21 July 2017

Mr David Gibson
Team Leader
Social Infrastructure Assessments
Department of Planning & Environment
GPO Box 39
SYDNEY NSW 2001

Statement of Environmental Effects to support a Section 96 (1A) to amend SSD 6980 to extend the approved awning to Pittwater Road at the Brookvale Community Health Centre

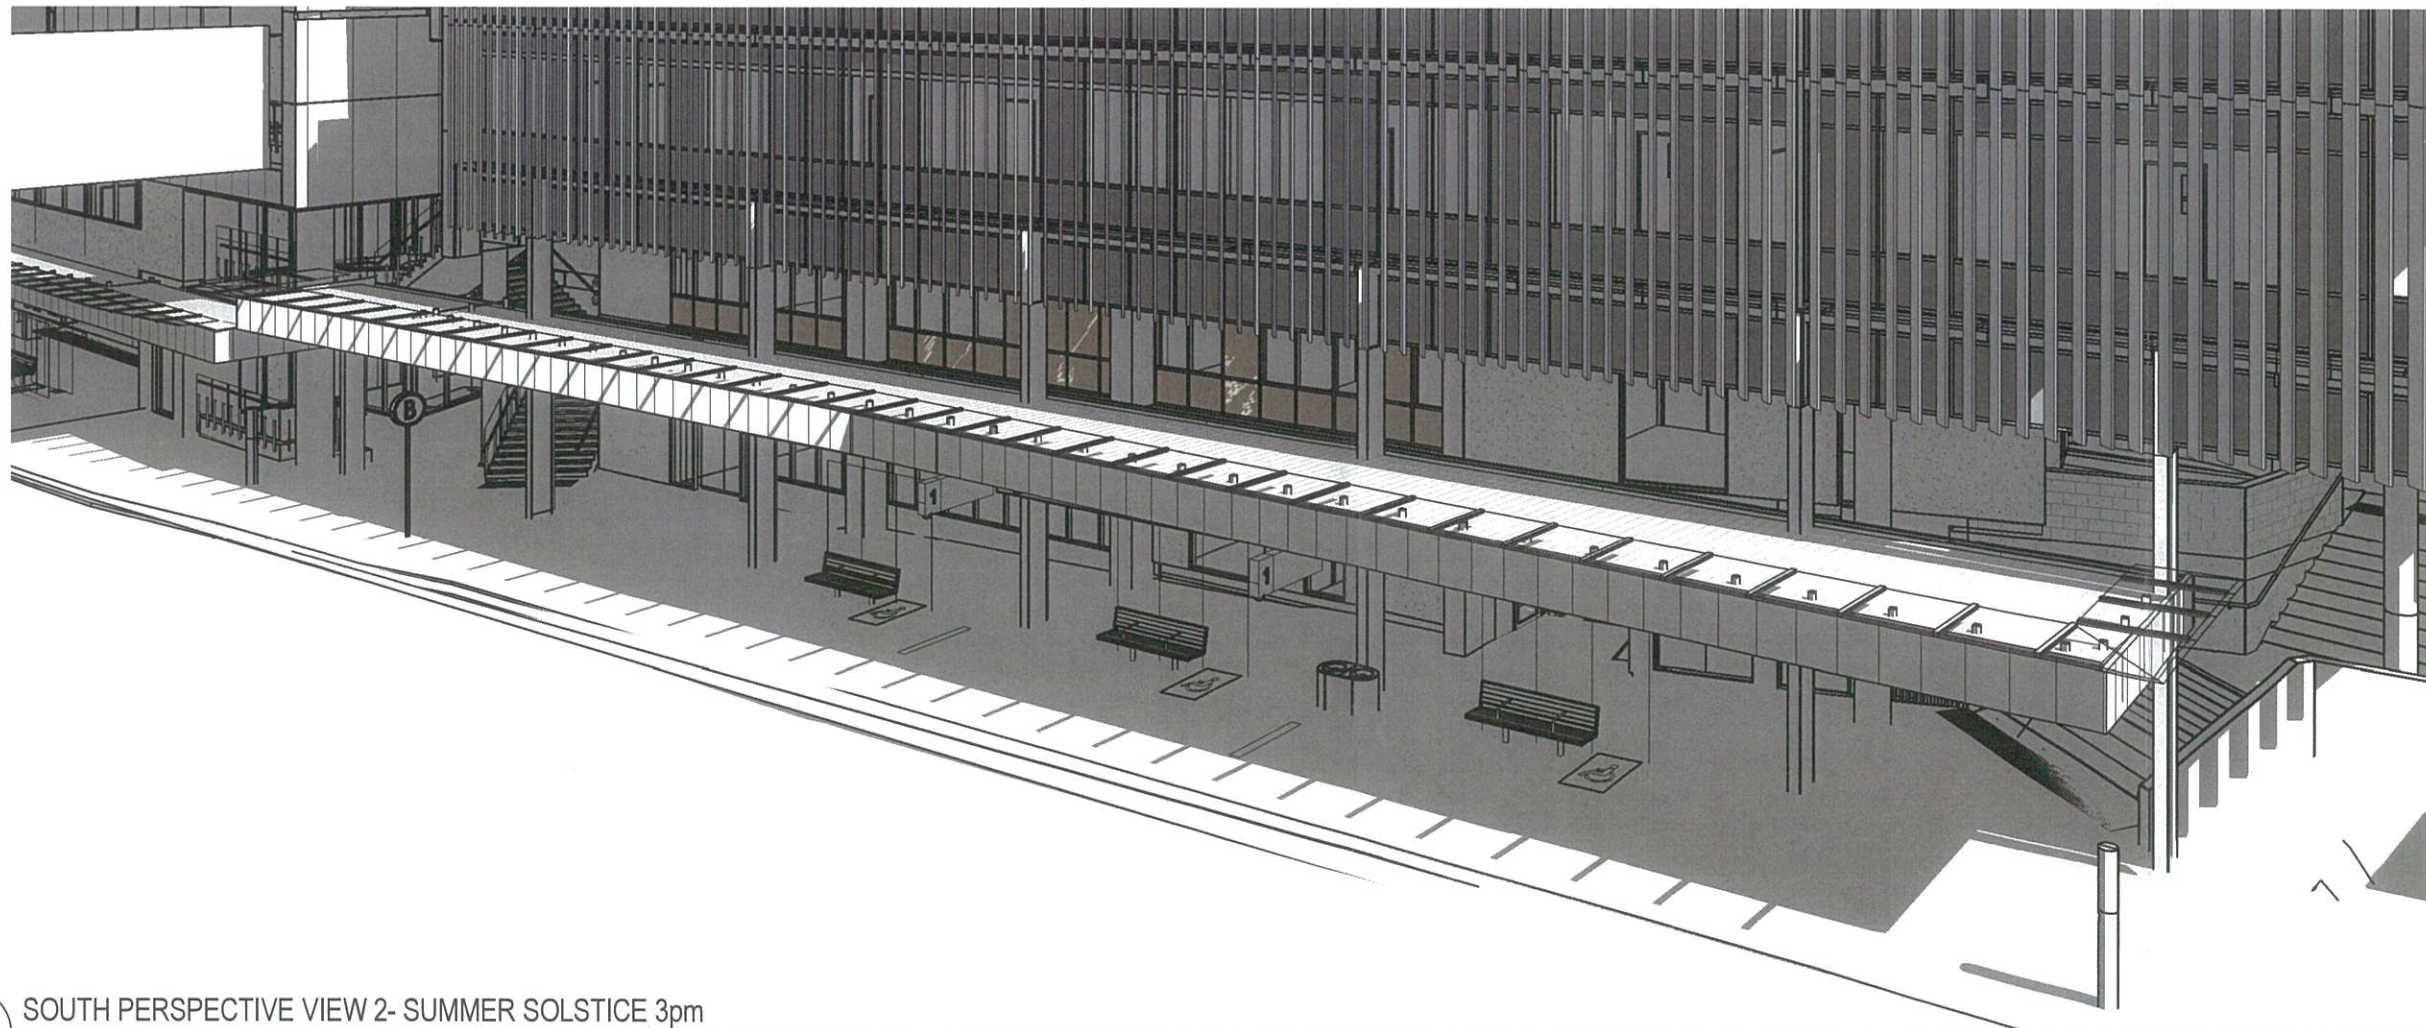
Figure 4: Perspective drawing of proposed awning extension as viewed from Pittwater Road looking north east
 Source: dwp architects – Perspective views TfNSW Awning (Drawing No. SK181 Issue B, dated 11/07/2017)

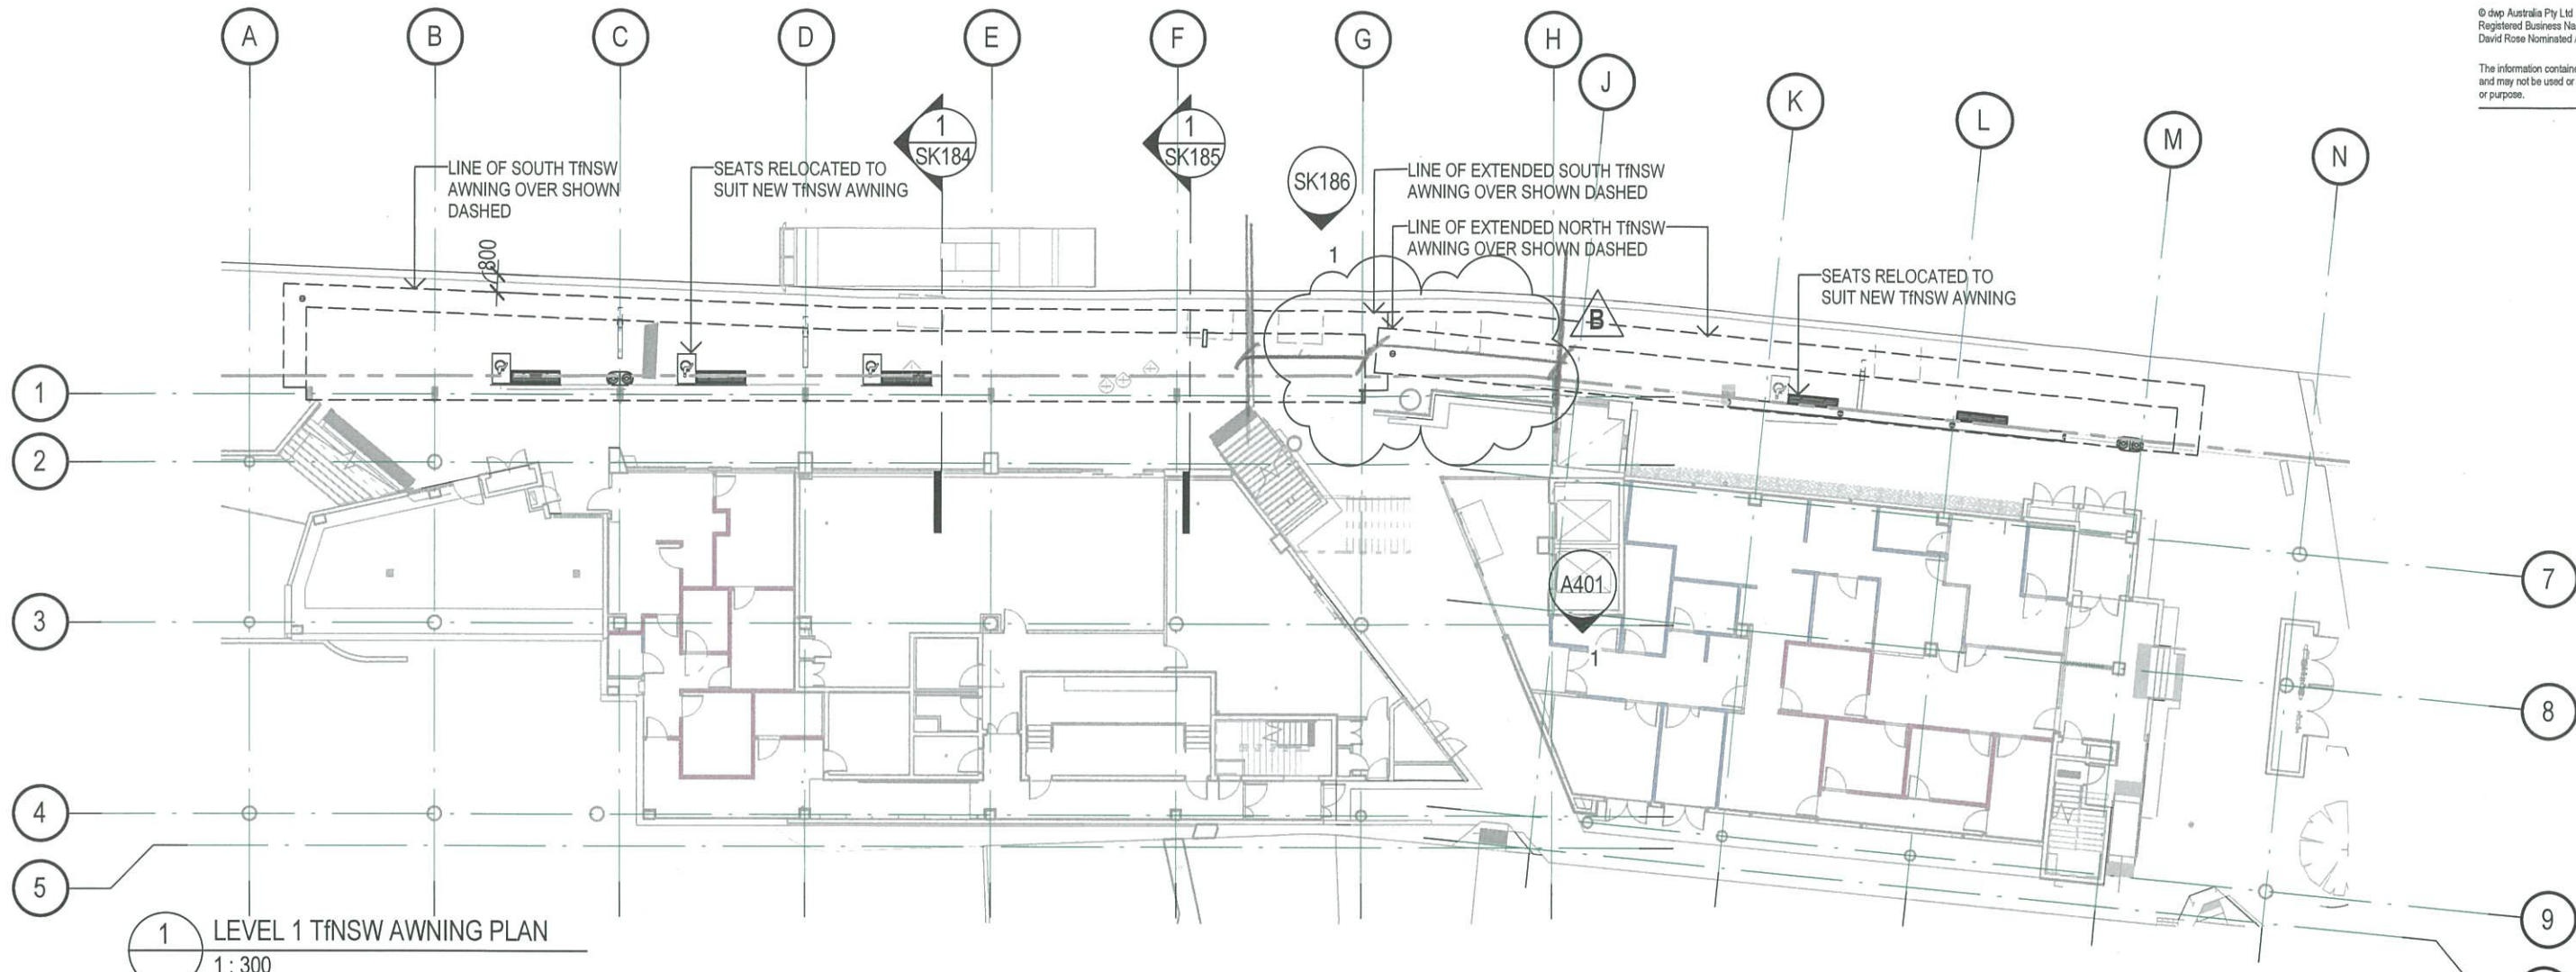
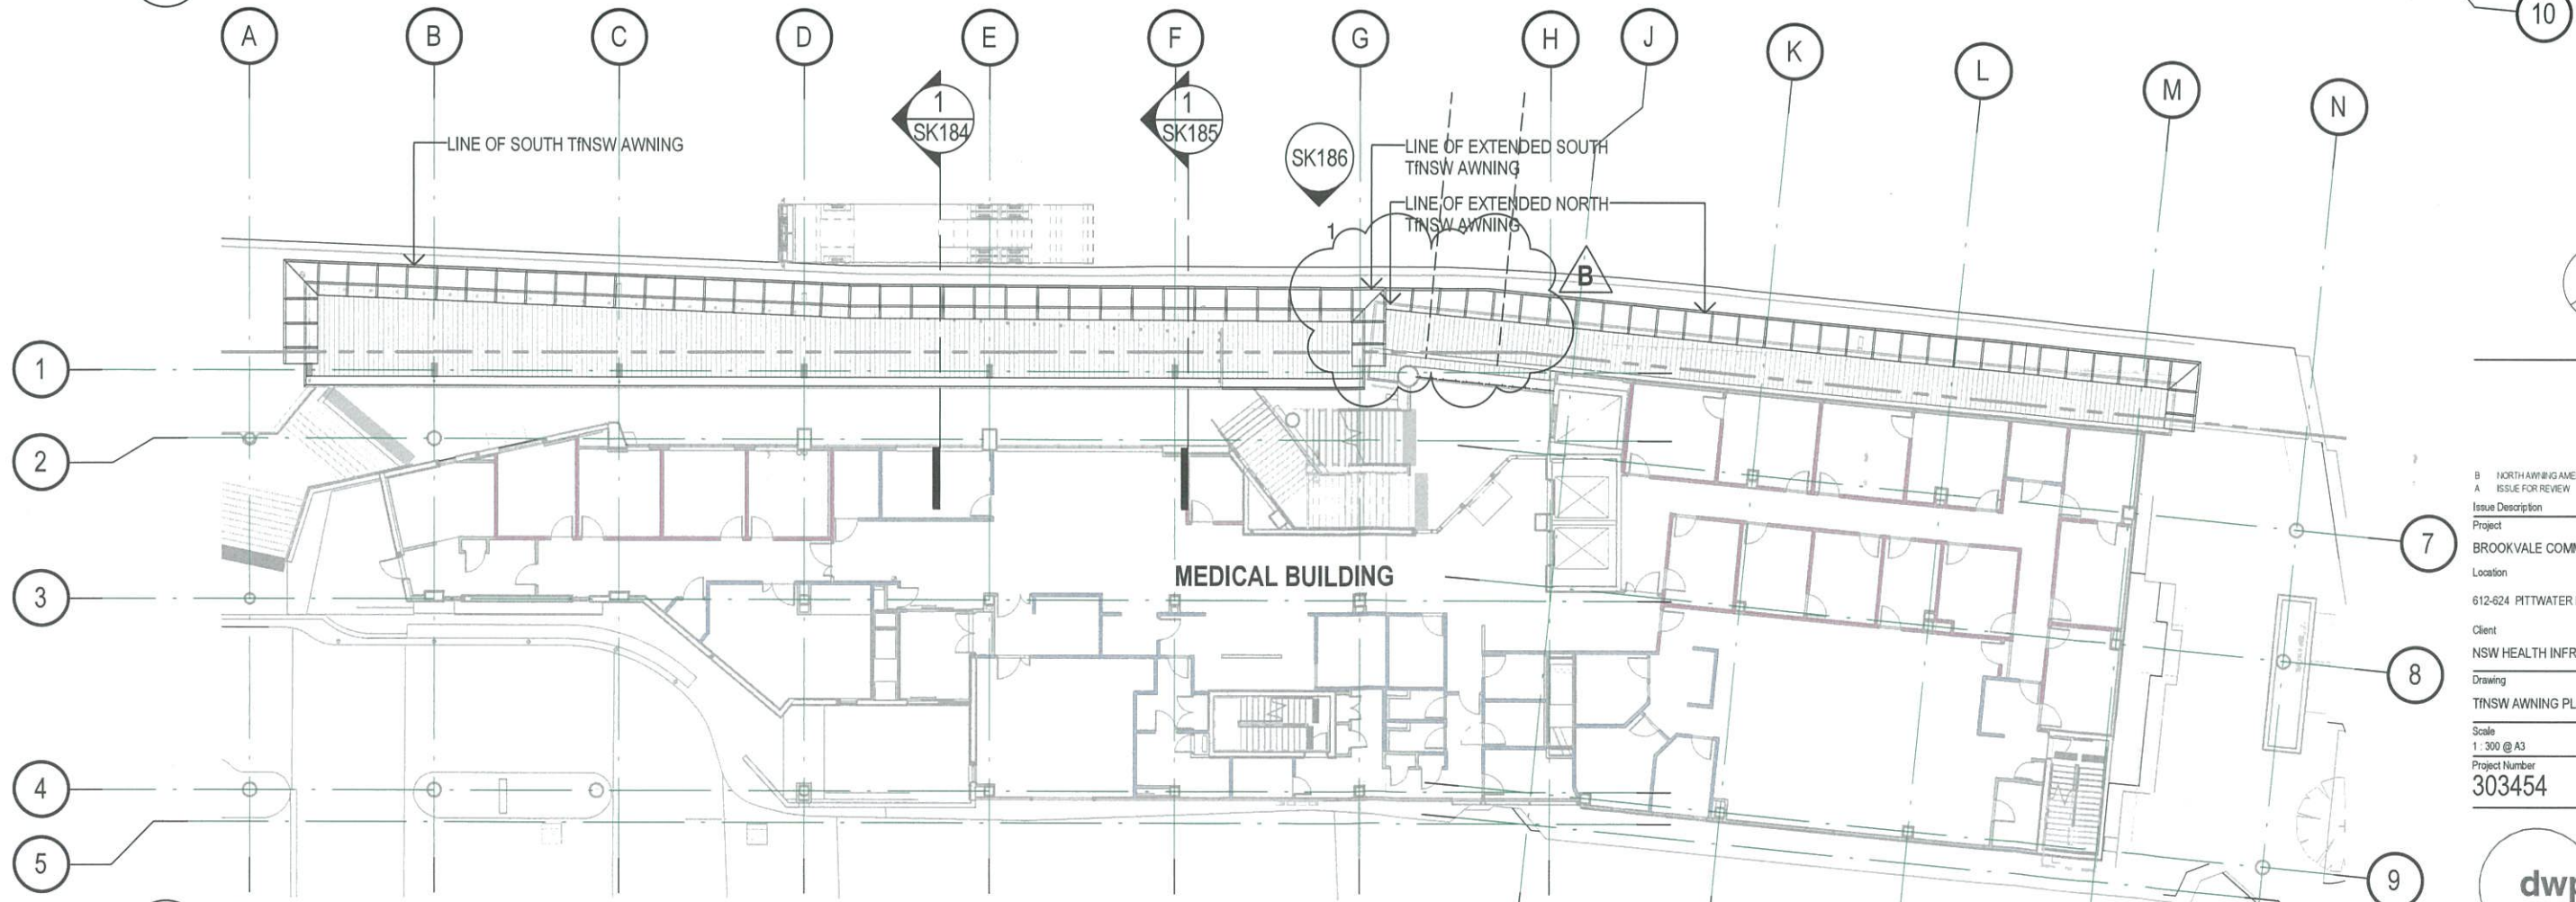
It is proposed to extend both the southern wing awning, and the northern wing awning, across the central breezeway section of the building. The design results in the awnings overlapping at the breezeway, to provide continuous protection to pedestrians and commuters across the entire Pittwater Road street frontage (refer to Figures 2, 3 and 4). The proposal will result in improved amenity for pedestrians and commuters.

Figure 2: Proposed awning extension
 Source: dwp suters architects – Level 1 Awning Plan (Drawing No. SK183 Issue B, dated 11/07/2017)

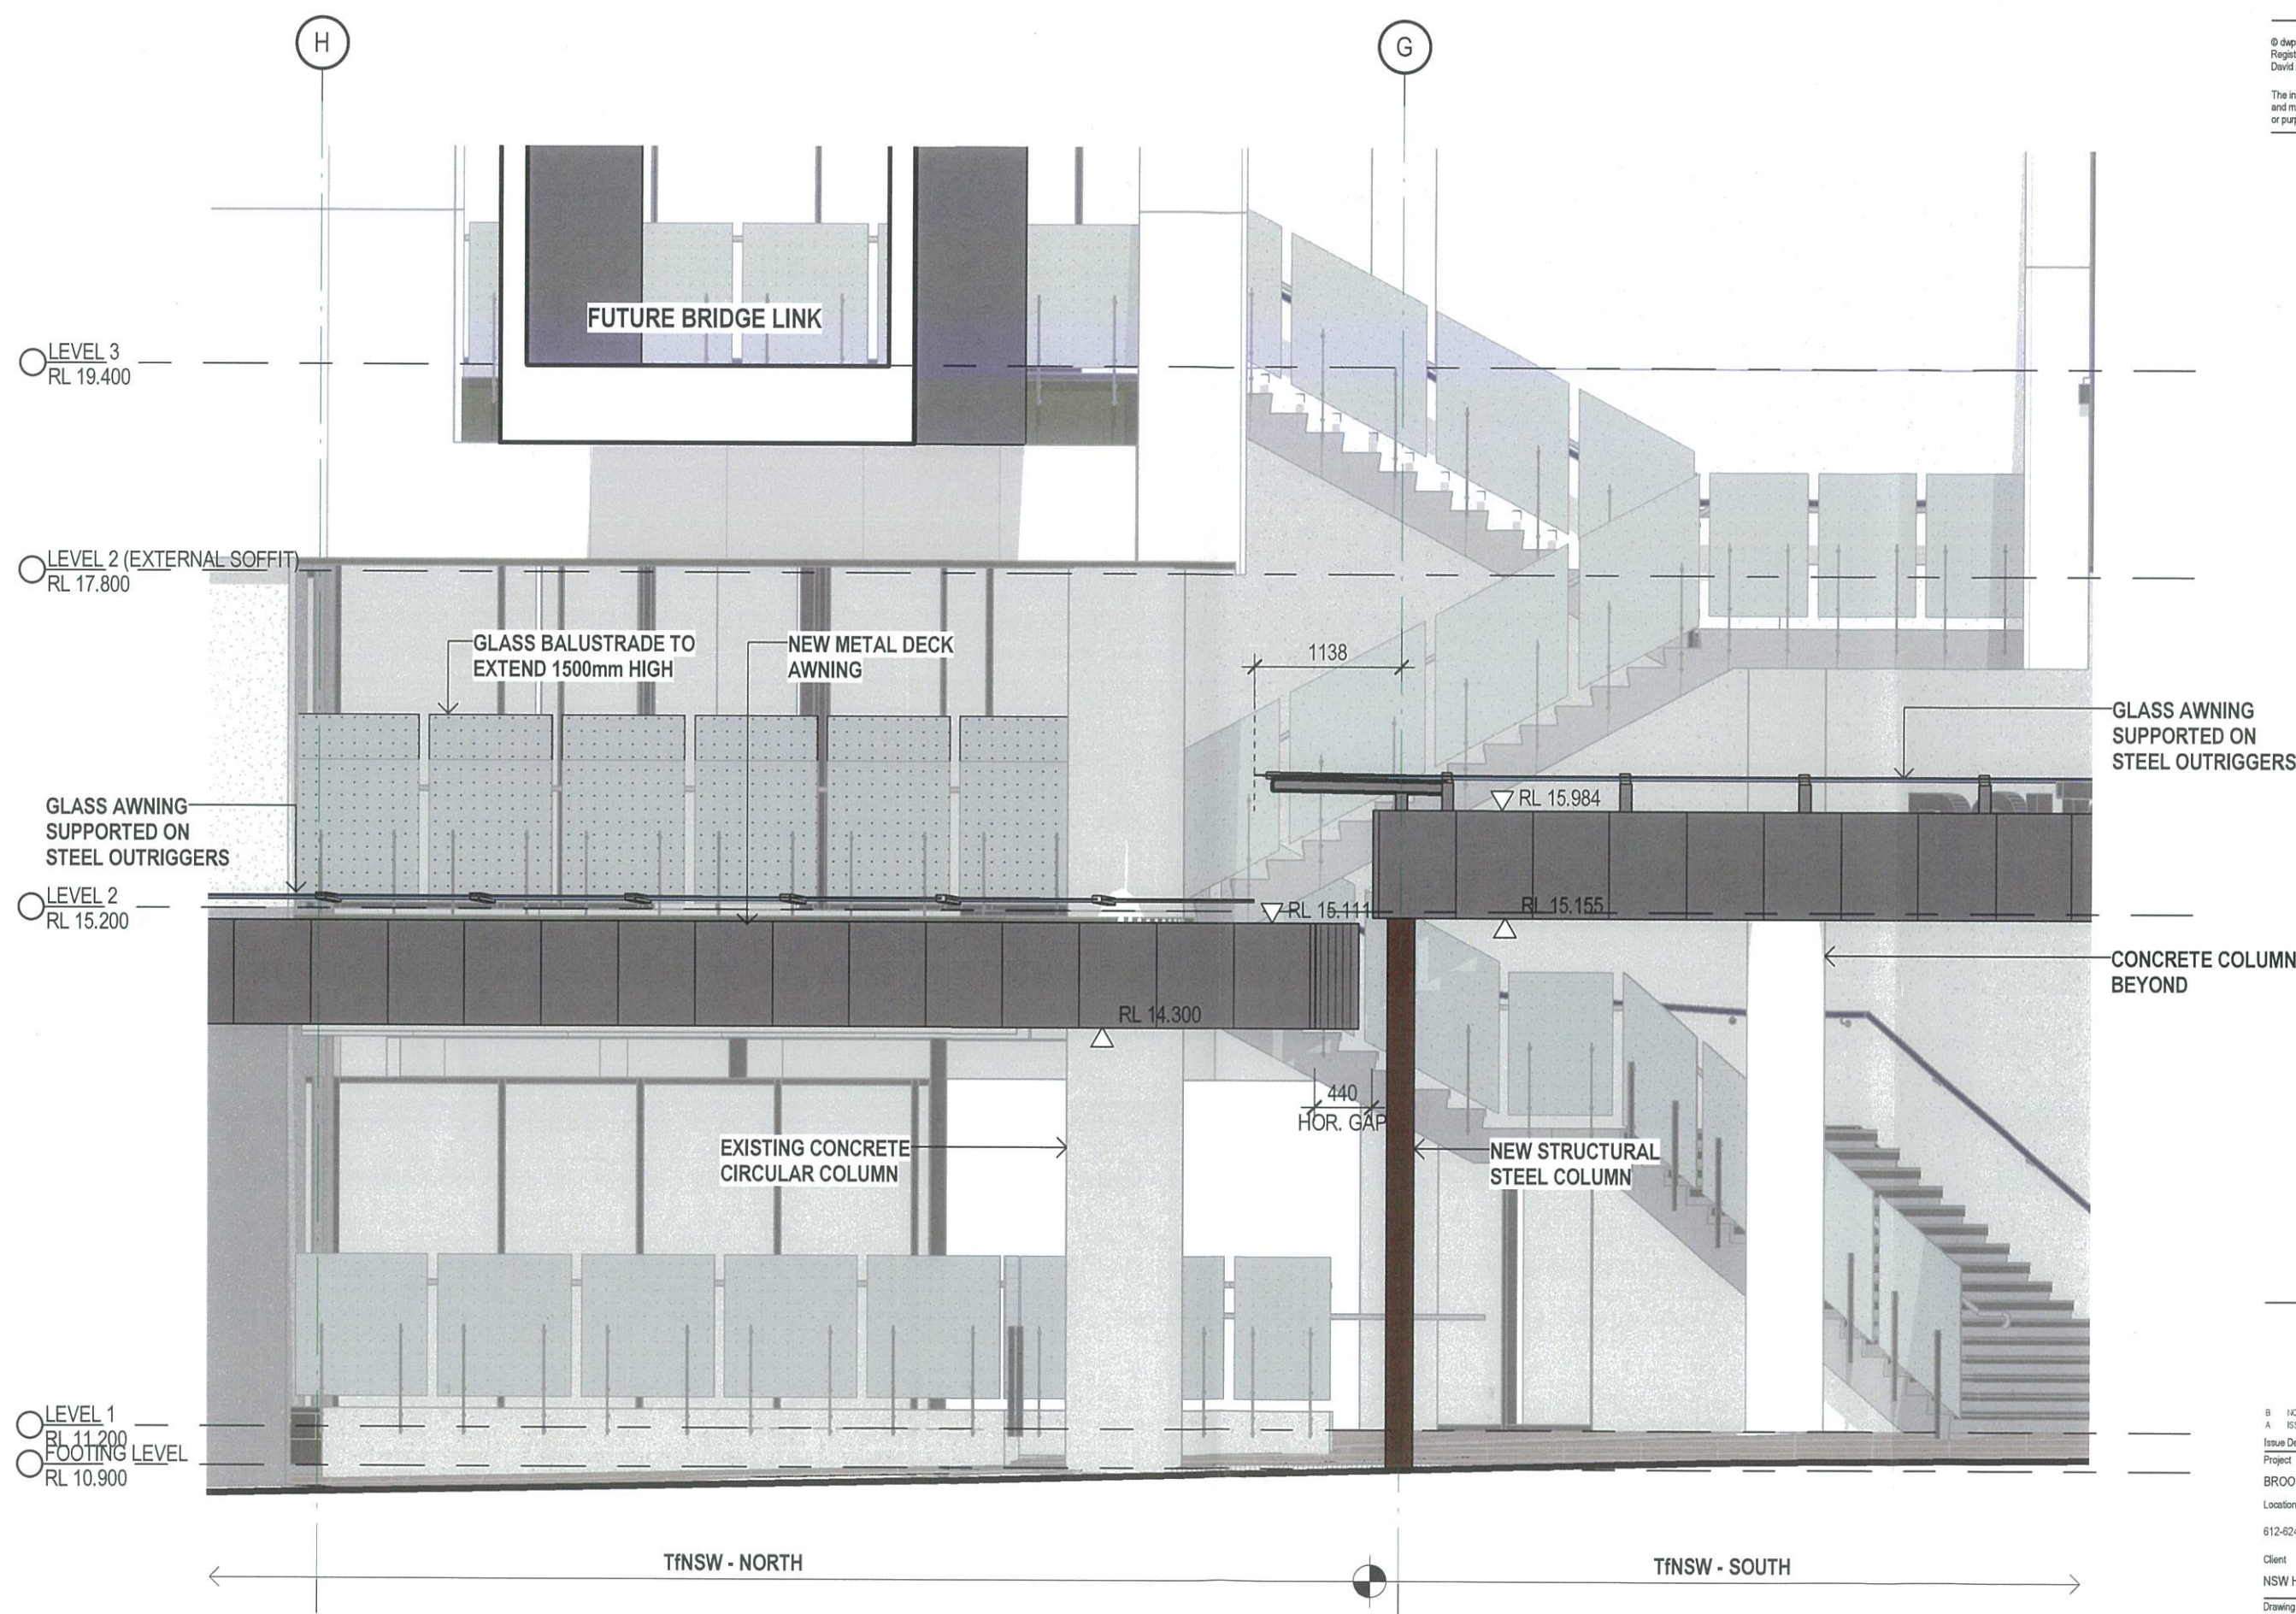
Figure 3: Proposed extension of North and South TfNSW Awning across breezeway
 Source: dwp architects – Part Elevation – North & South TfNSW Awning (Drawing No. SK186 Issue B, dated 11/07/2017)
